Please ask for: Ms Iqraa Malik
Email: iqraa.malik@terraquest.co.uk
Telephone: 0121 234 1390
Our Ref: CM/45/24/HH
Your Ref:
Date: 27th November 2024

Application for Planning Permission for Works or Extension to a Dwelling

Development: Part single, part two storey side and single storey rear extensions and creation of a drive, following demolition of existing extensions.
Location: 2 Rose Cottages Climping Street Climping BN17 5RH

DRAWING TITLE  
Proposed Floor Plans and Site Plan

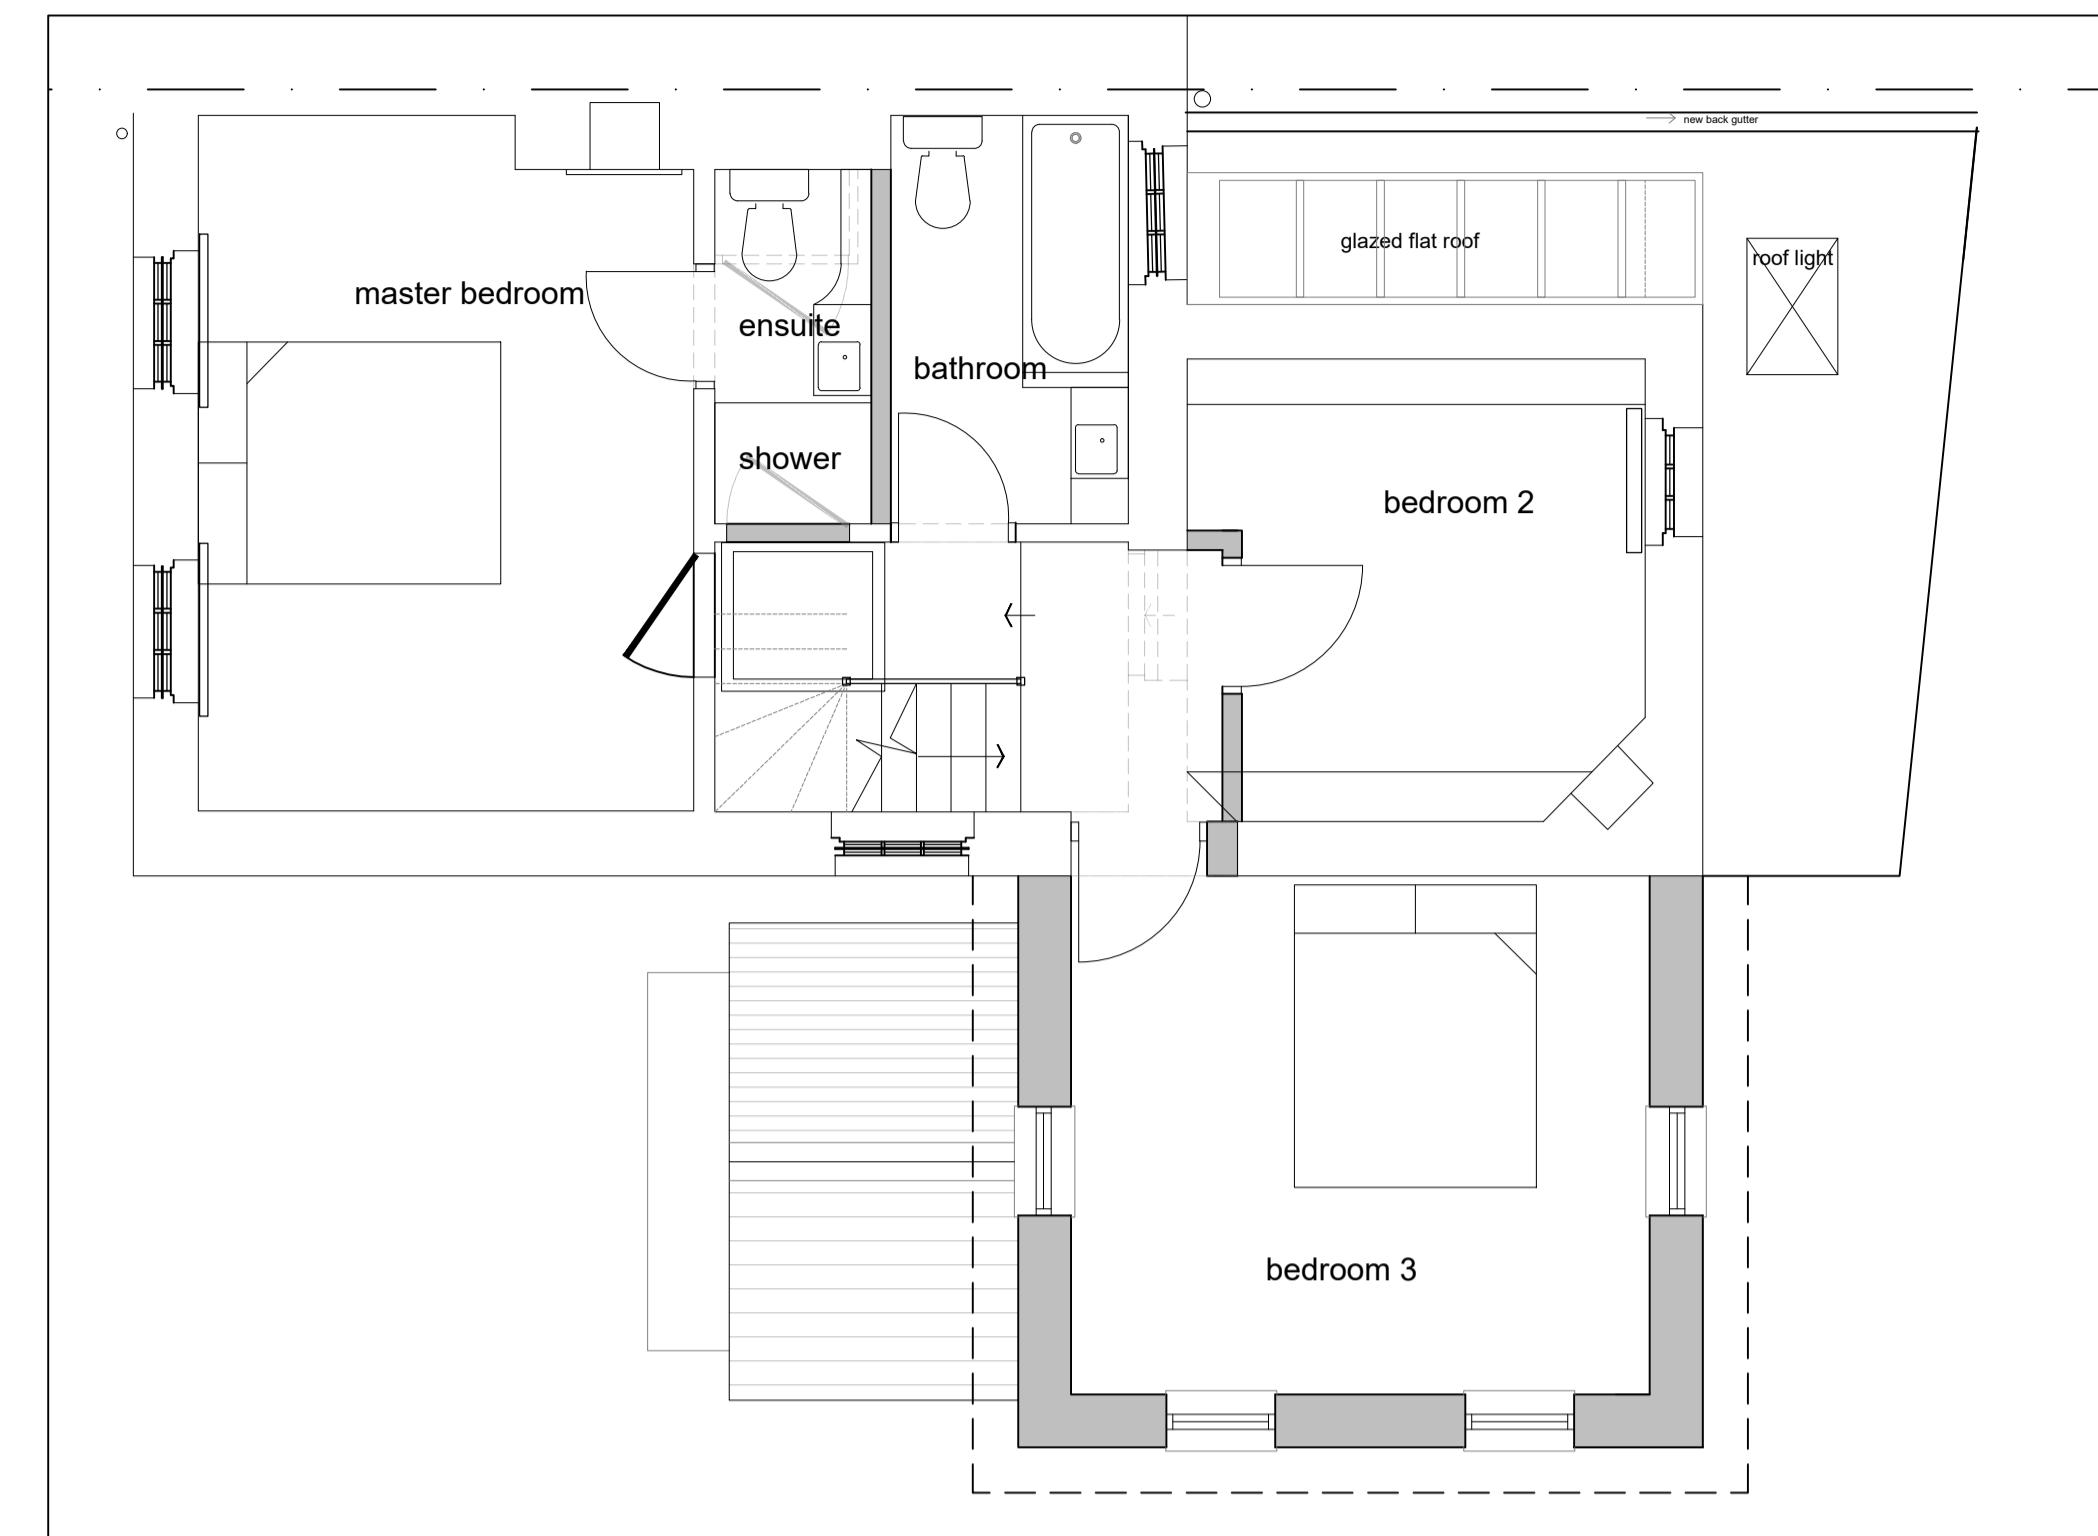
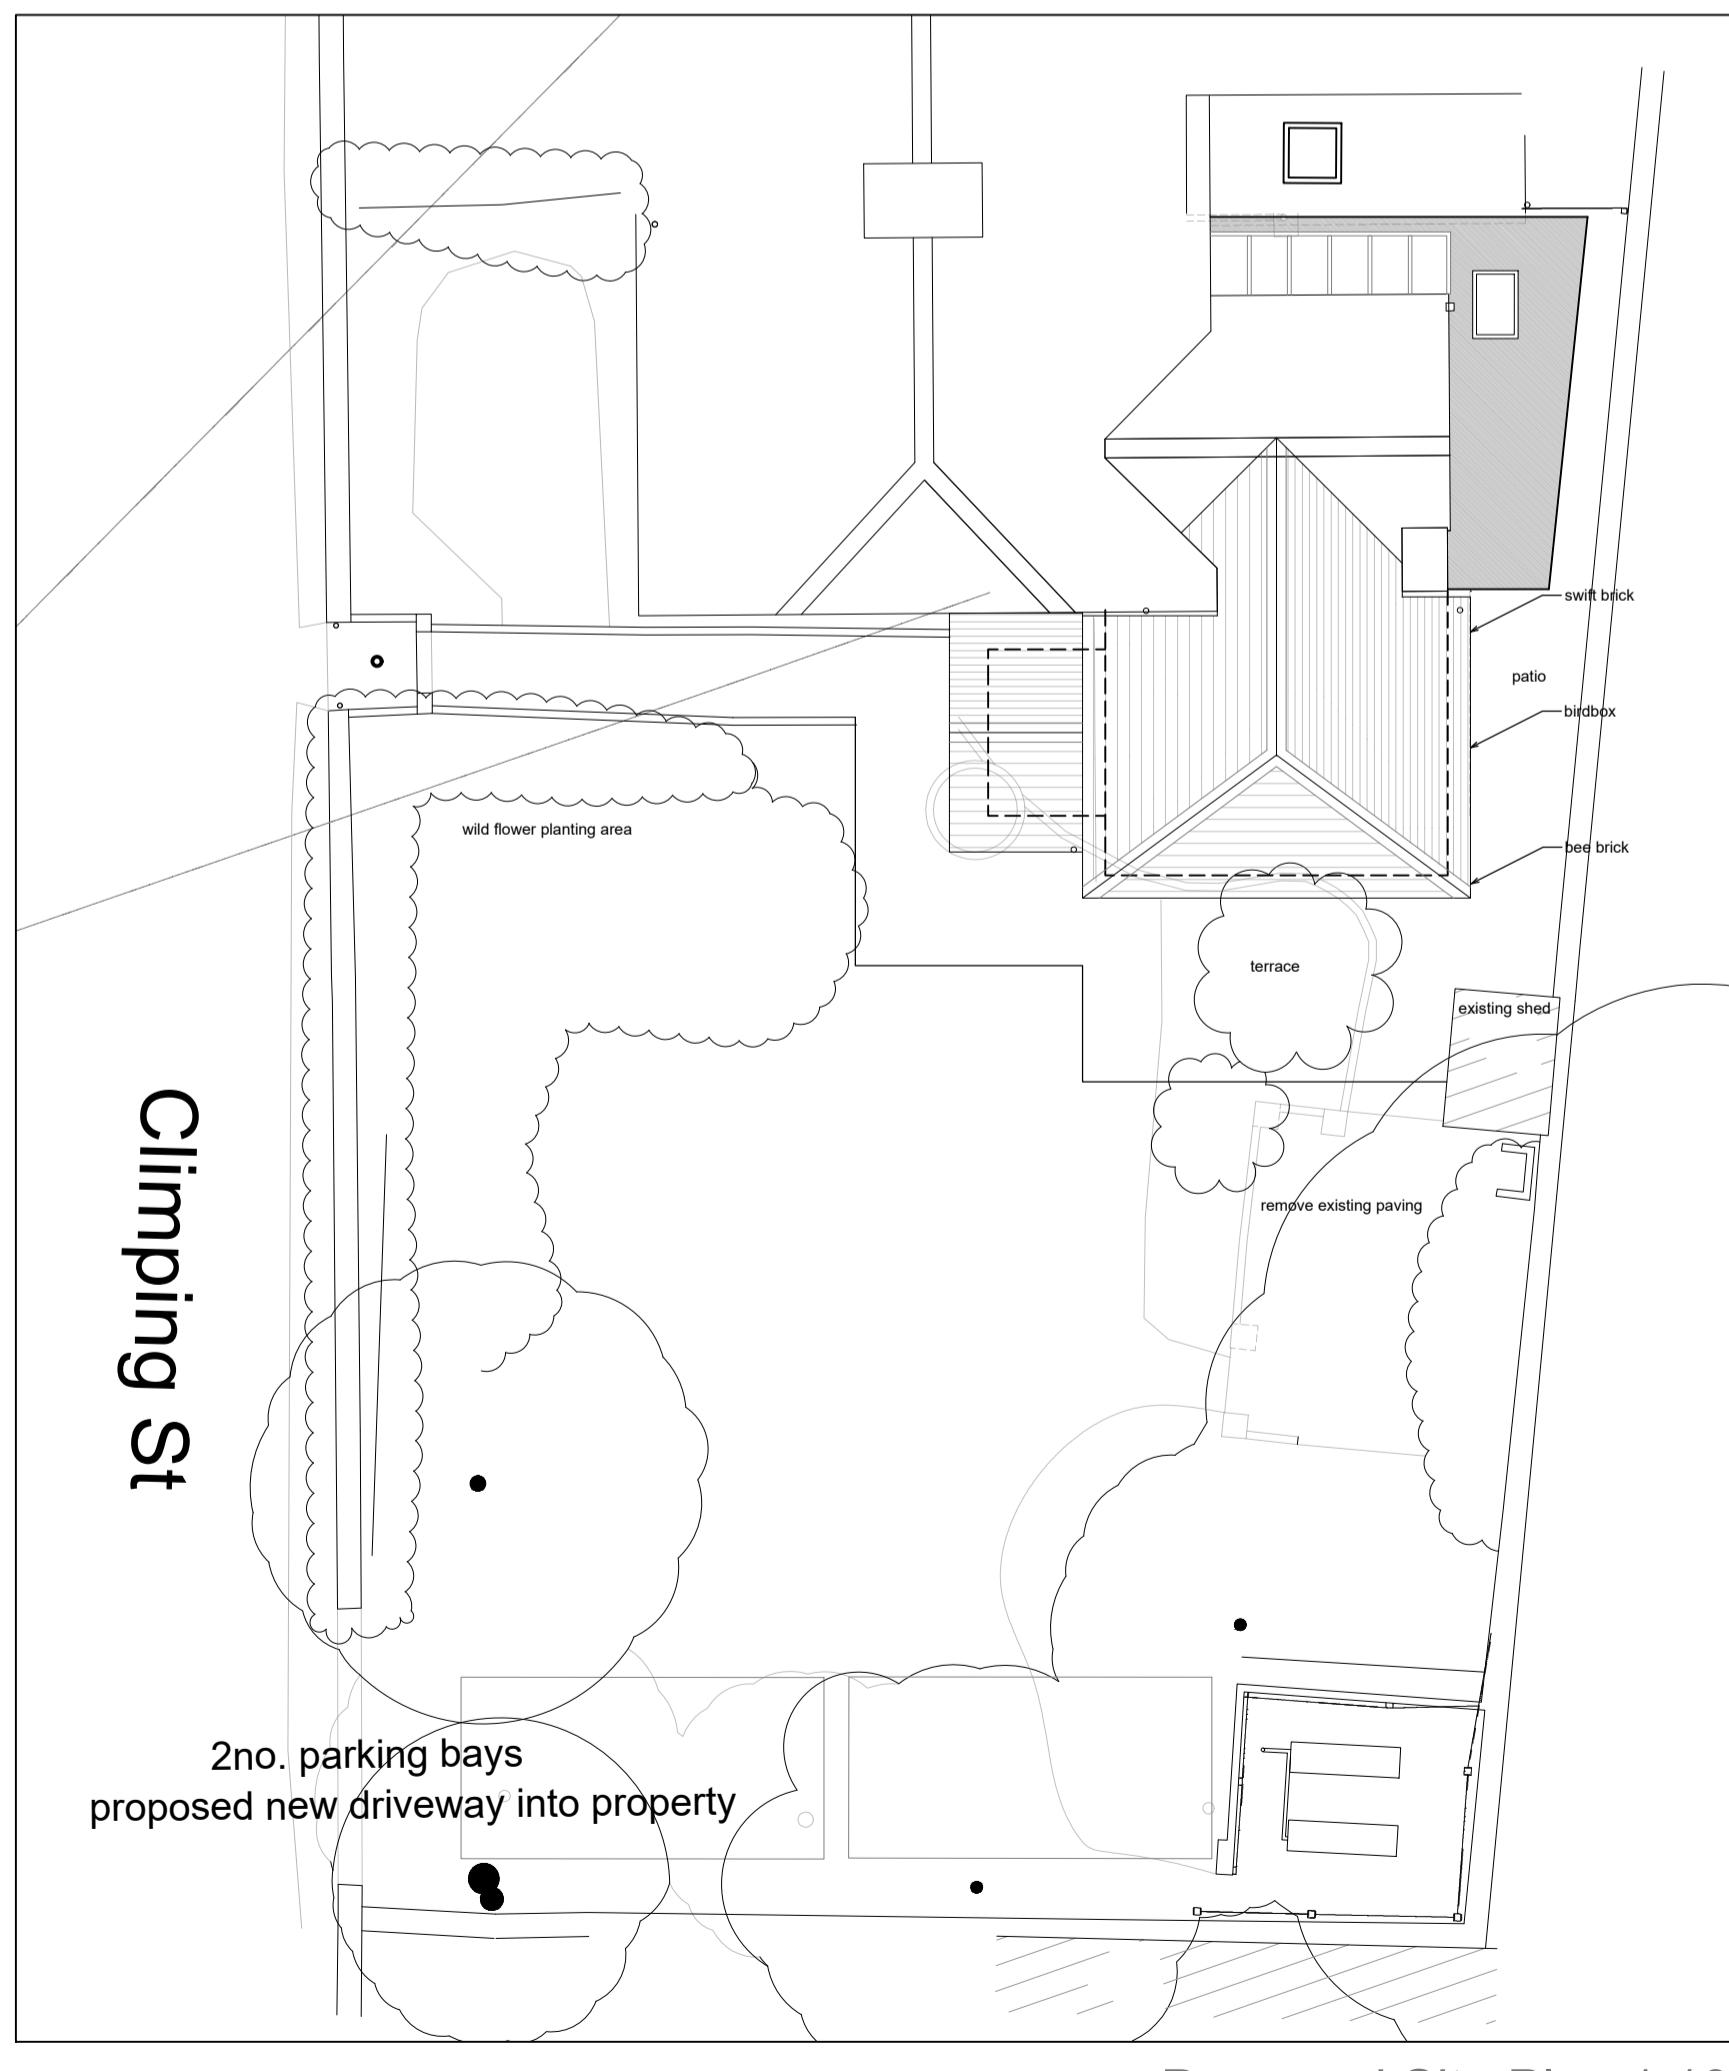
According to our GIS, Climping Street is not a private road, therefore there is no need to extend the red outline all the way up to Crookthorn Lane on the site plans, please review and amend.

You are required to have dimensions from the proposed extension(s) to all site boundaries. Please amend.
